# KITTITAS COUNTY

## DEPARTMENT OF PUBLIC WORKS

### MEMORANDUM

**TO:** All Staff  
**FROM:** Public Works Plan Review Team  
**DATE:** July 28<sup>th</sup>, 2023  
**SUBJECT:** Public Works Comments: BL-23-00014 Suncadia Resort LLC

3. THE PURPOSE OF THIS SURVEY IS TO DEPICT THE NEW BOUNDARIES RESULTING FROM KITITAS COUNTY BLA APPLICATION BL-23-00014.

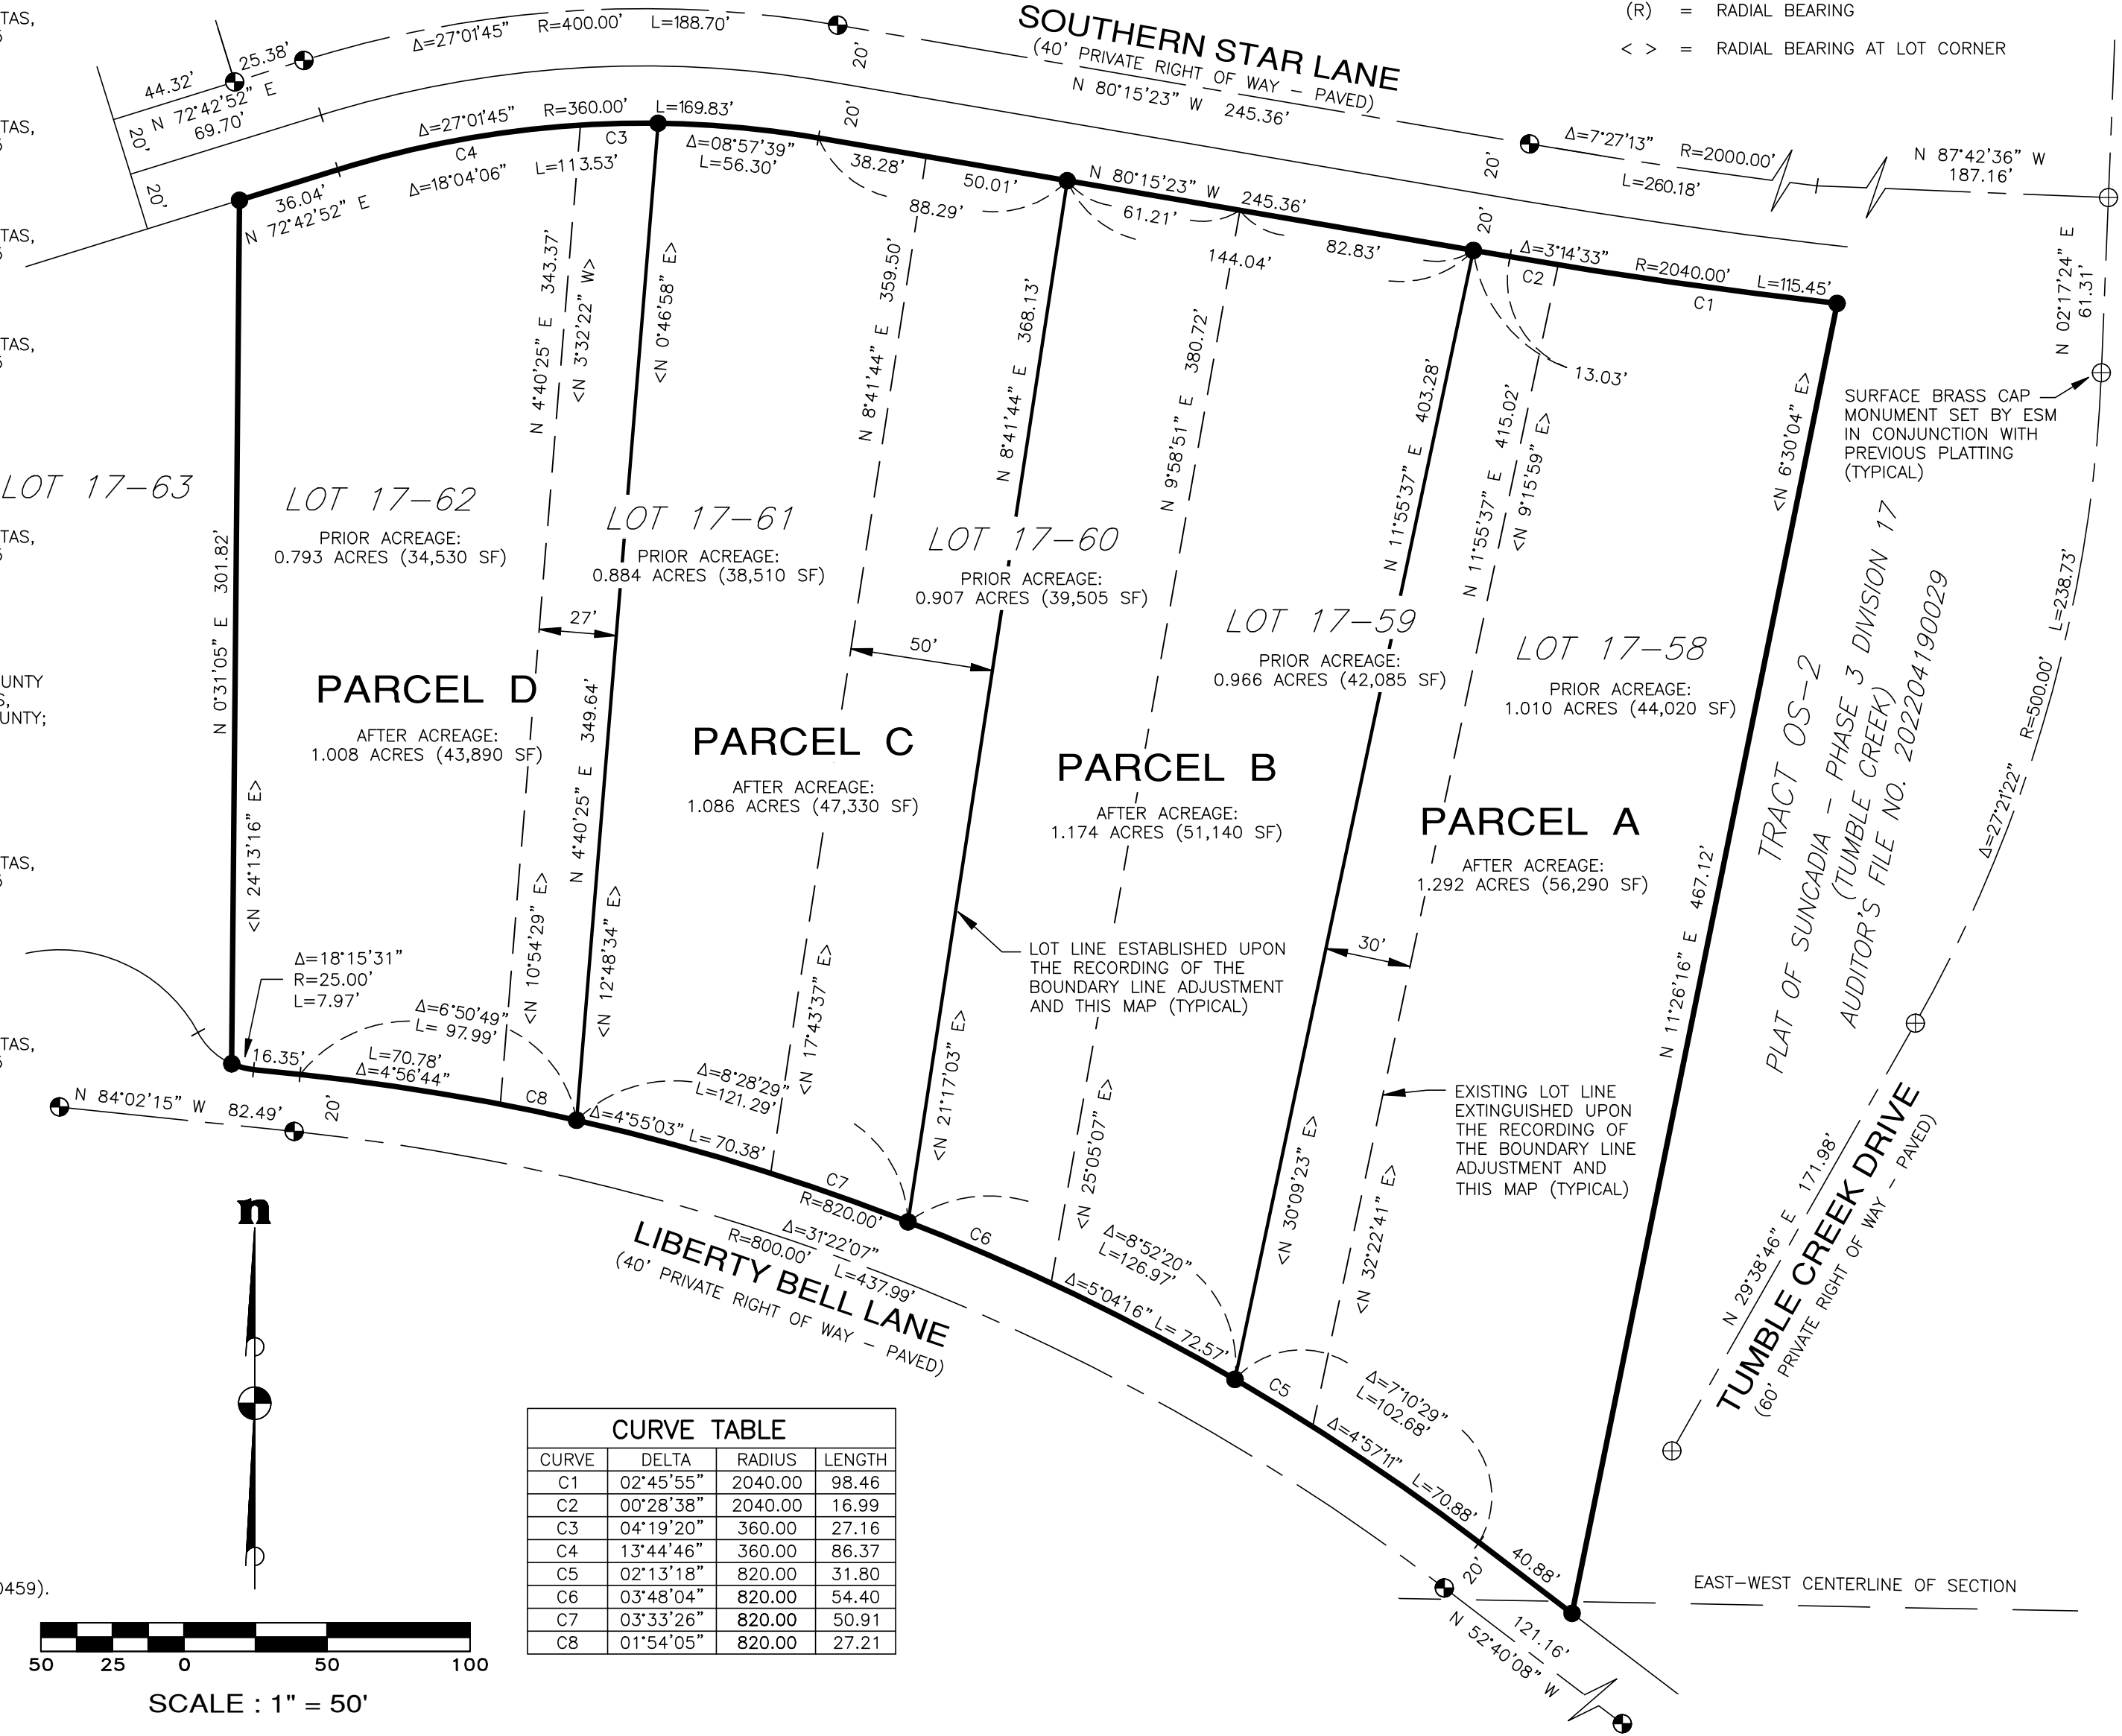
| <b>SURVEY</b>   | Survey comments below reflect requirements for Final Survey submittal.<br>1. Show existing survey control utilized to establish new set corners.<br>2. Provide Lot Closure reports for new boundaries. (JT) |
